Our Ref: FP/177/11/
Your Ref:

19th September 2011

Demolition of existing dwelling to be replaced by 3/4 storey detached town house.
Amendment following FP/49/09/
Gull Point Outram Road Felpham

Ground Floor

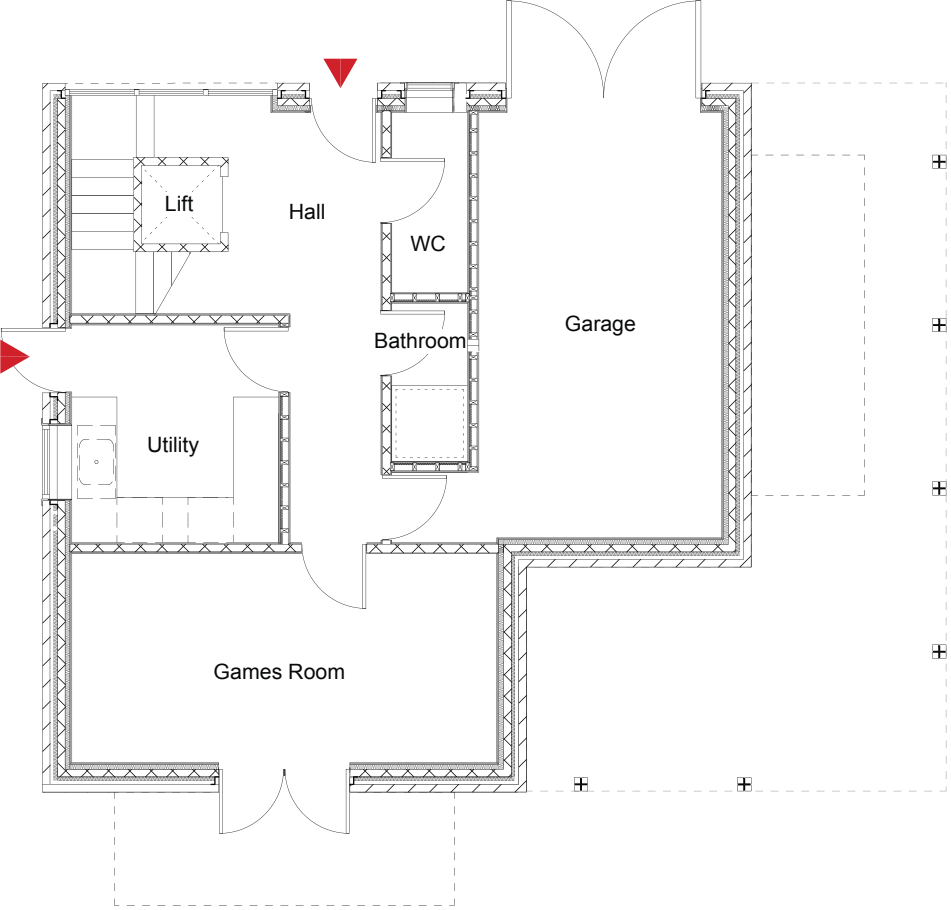
Please provide 1 electronic or 3 paper copies of a revised proposed ground floor plan to show the window (entrance/lobby) detailed on the proposed north elevation. ✓

Please provide 1 electronic or 3 paper copies of revised proposed floor plans to show all the rooflights detailed on the roof plan and elevations. ✓
